WHALLEY PARISH COUNCIL

Planning Application No: 3/2026/0336

Proposal: Proposed two-storey side extension and entrance canopy (resubmission of 3/2025/0753)

Location: 22 Clitheroe Road Whalley BB7 9AB

Client		
Mr Ousby		
Job Title		
Proposed Side Extension		
22 Clitheroe Road		
Whalley		
Drawing Title		
Proposed Plans and Elevations		
PLANNING STATUS		
Scale	Date	Drawn
1:50/100 @A2	May 2025	CC

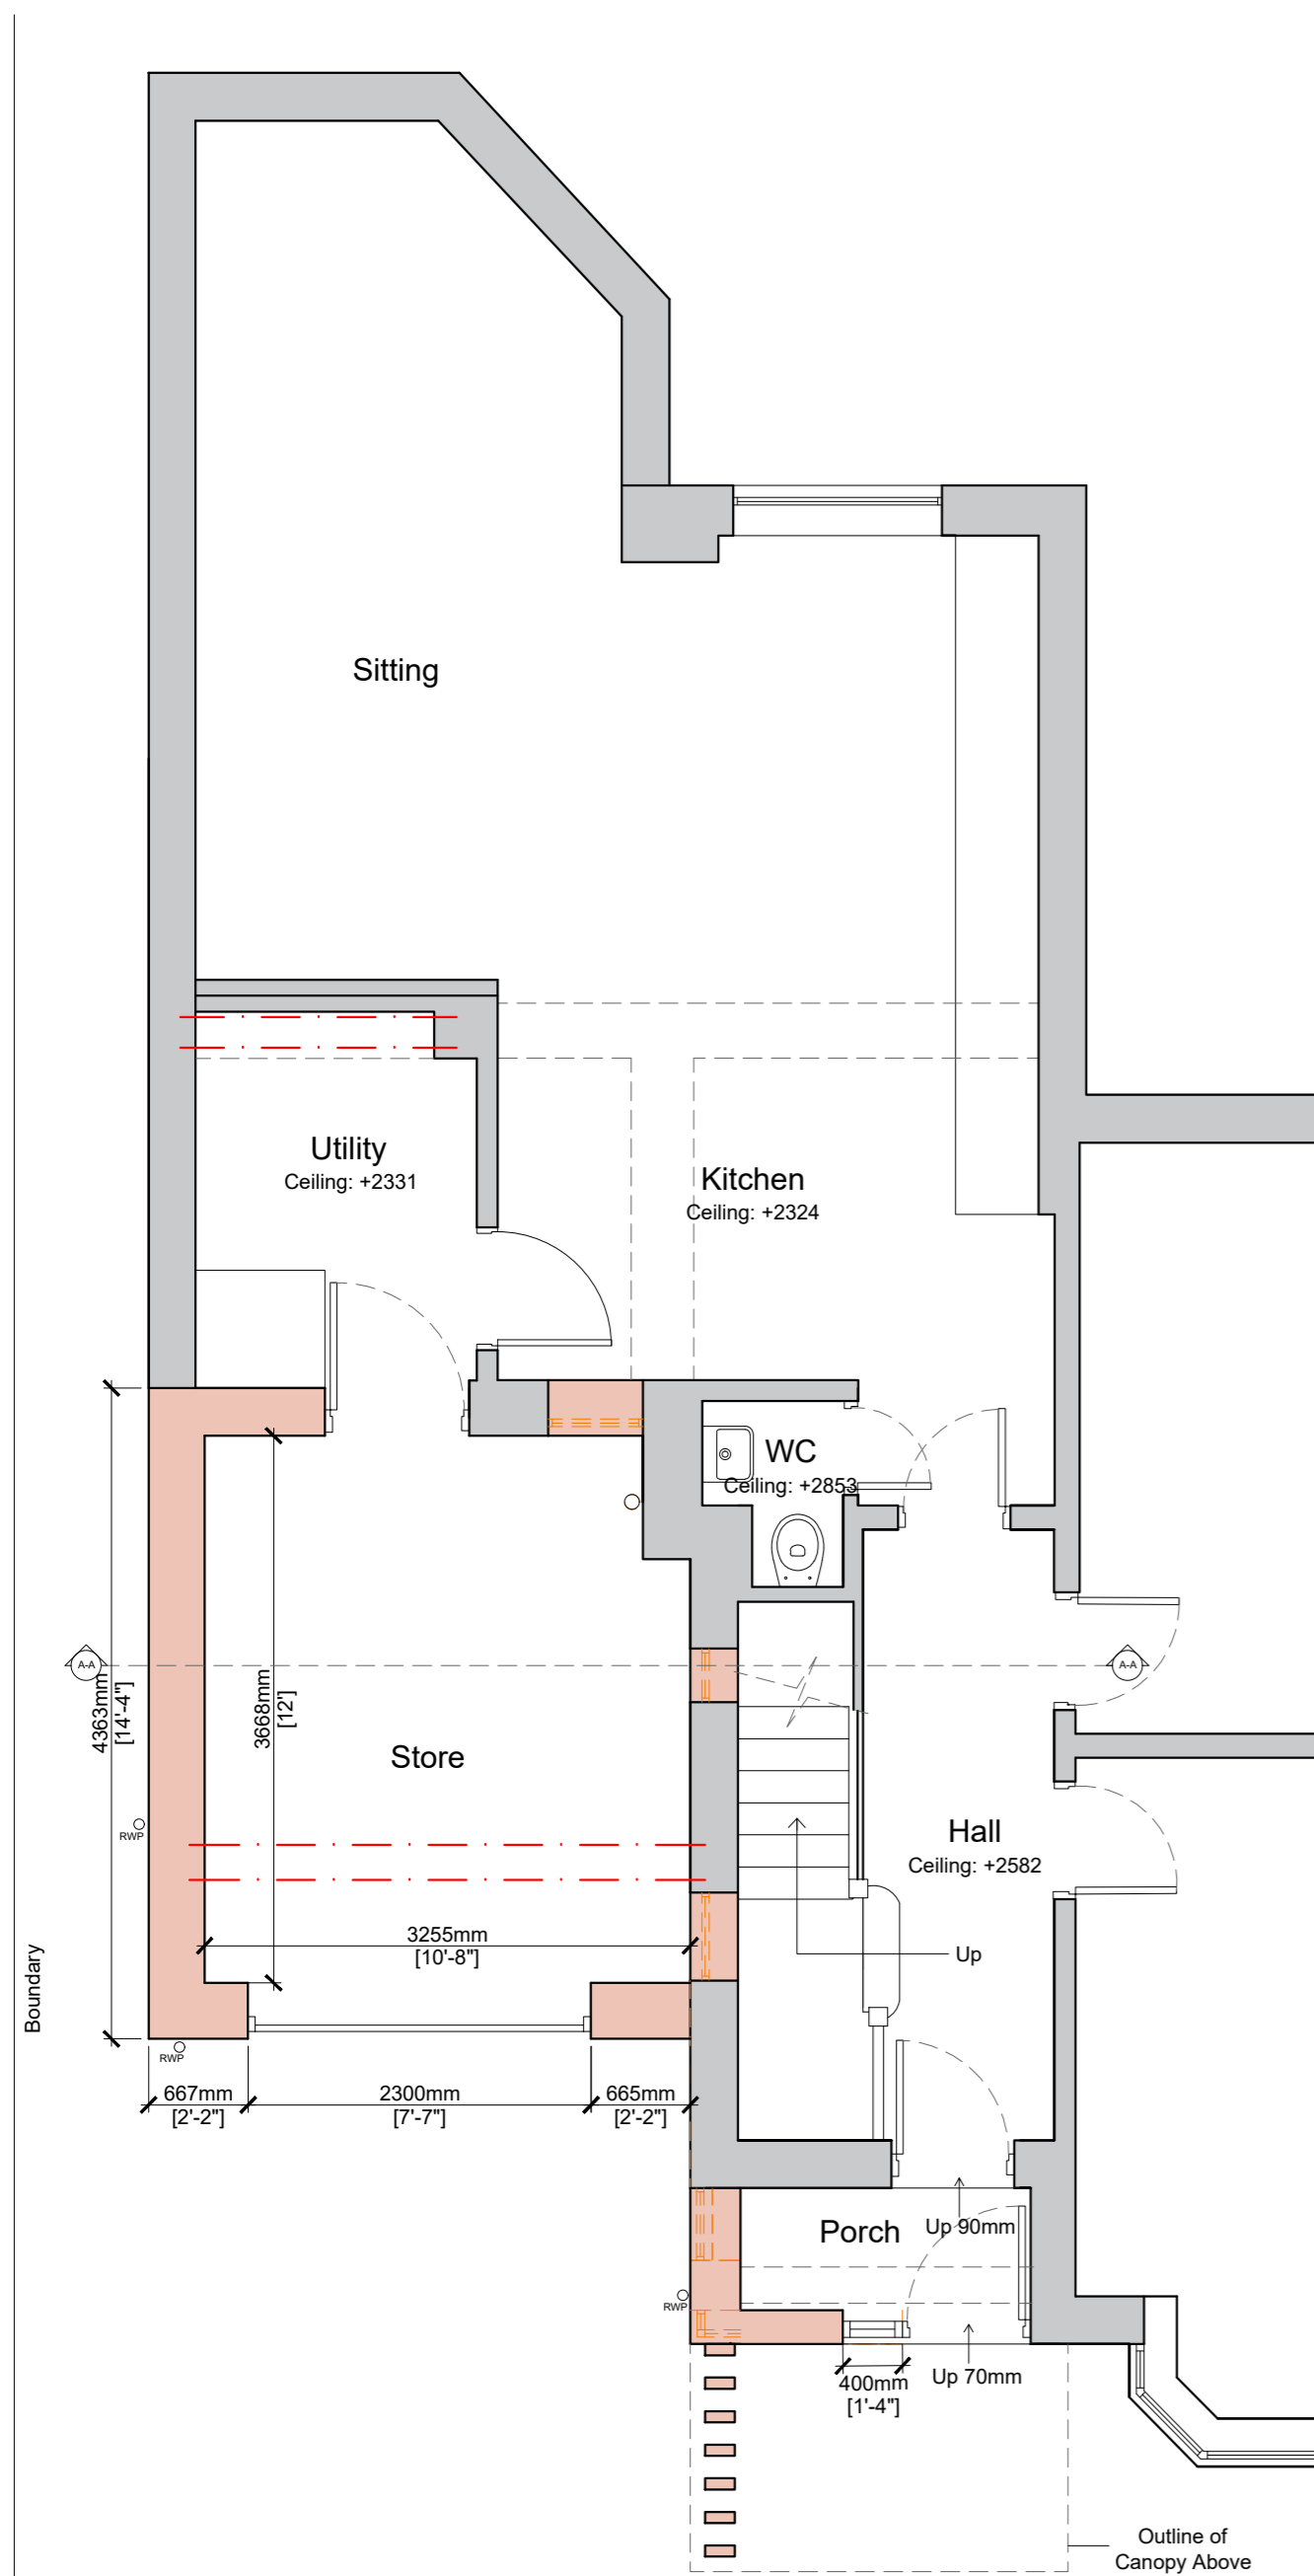
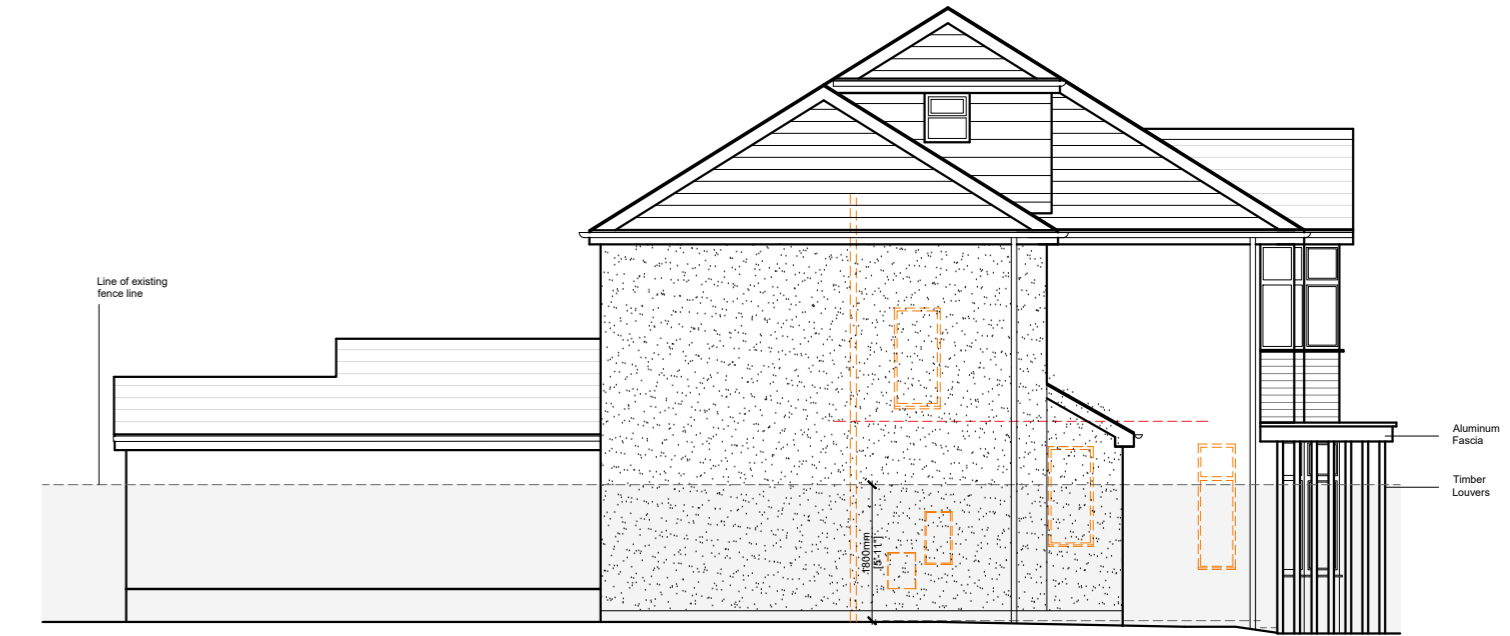
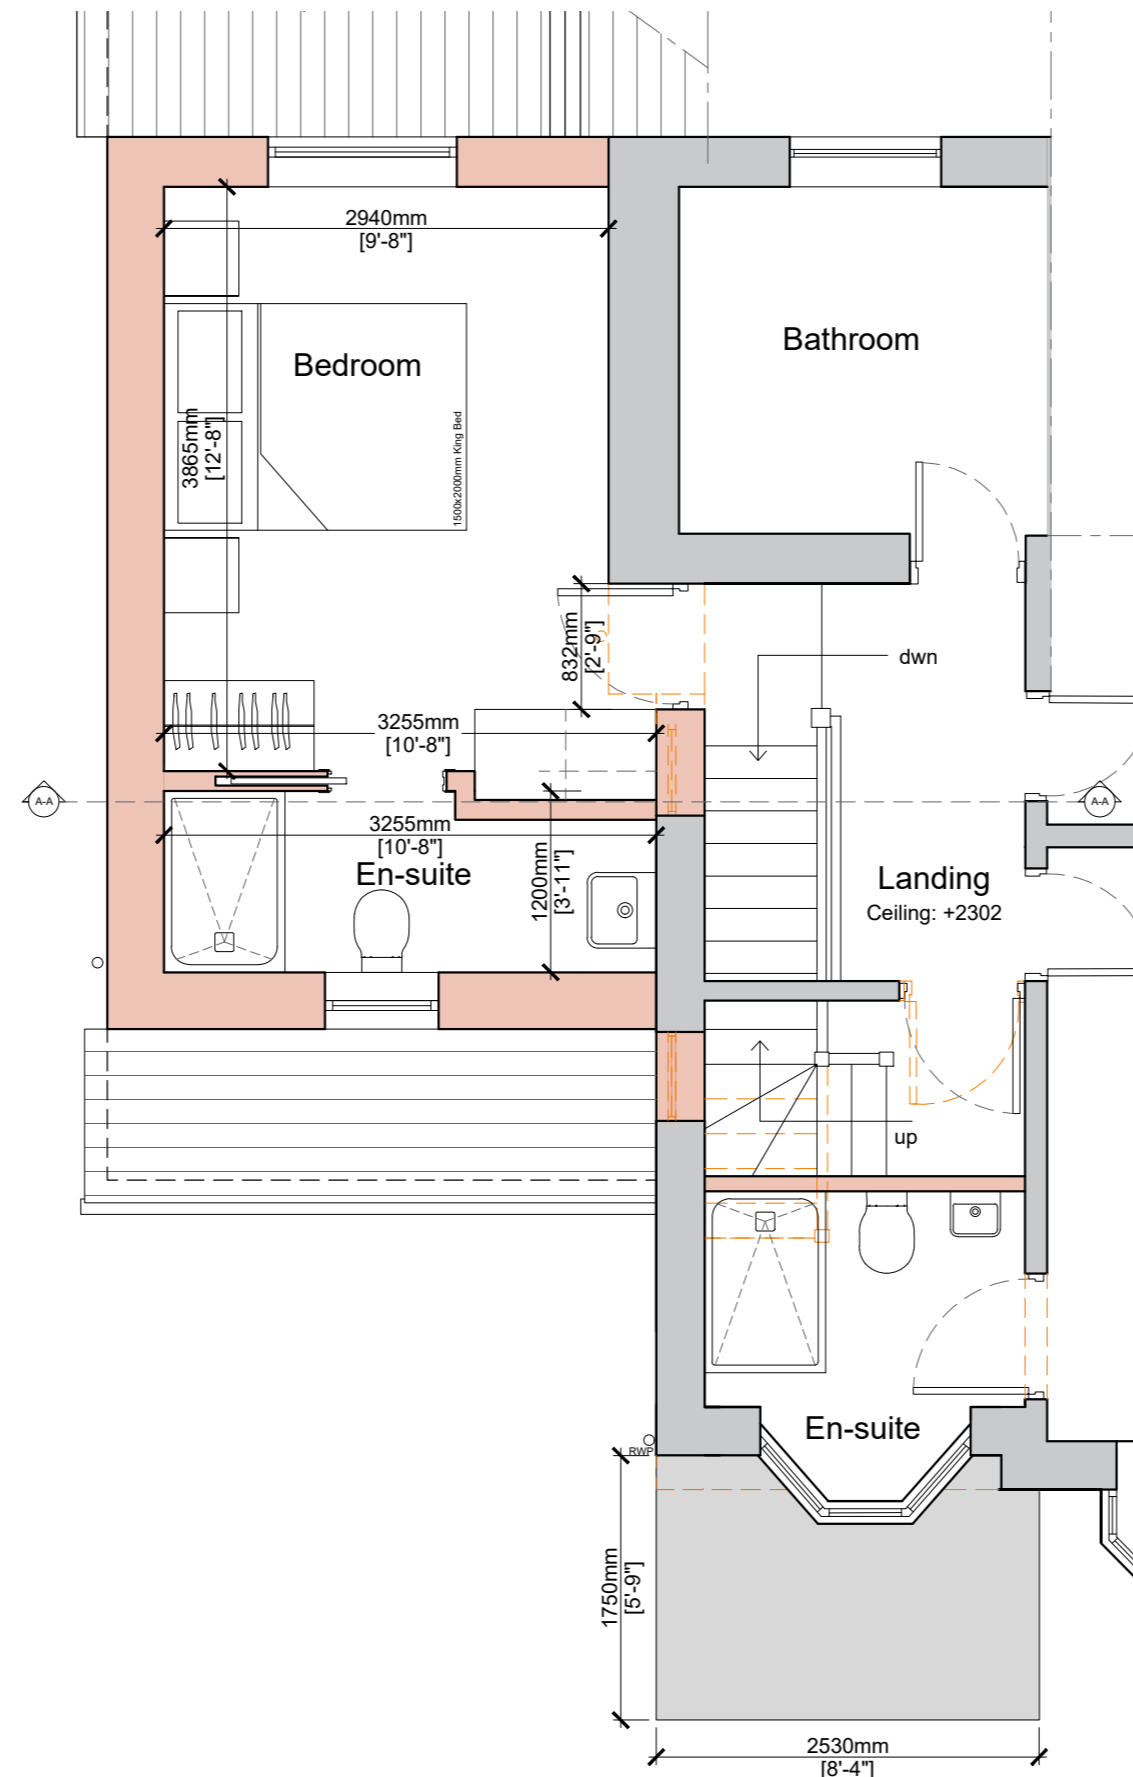
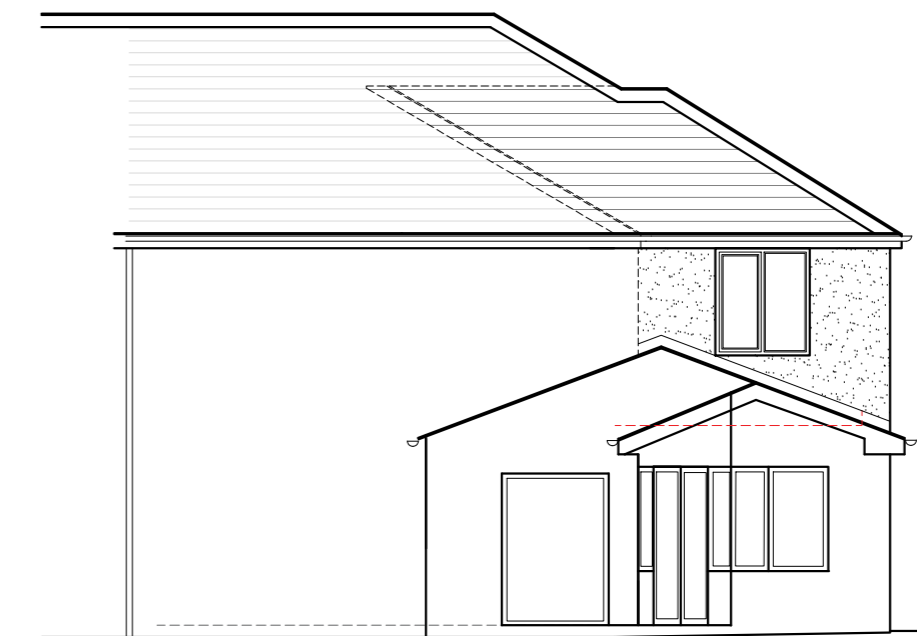
Whalley Parish Council's concerns regarding the scale and massing of the proposed development remains. It is the Council's view that the size of the two-storey side extension and entrance canopy represents overdevelopment of the plot, resulting in a structure that appears disproportionately large in relation to both the original property and the neighbouring houses.

The proposed extension would significantly increase the footprint of the existing house and reduce the visual spacing between properties, affecting the street scene of Clitheroe Road and may set an undesirable precedent for future oversized extensions in the area.

We respectfully request that the Planning Authority considers whether the proposal, in its current form, is sympathetic to the scale, character, and pattern of development within this part of Whalley and would suggest that a reduced and more proportionate design may be more appropriate for the site.
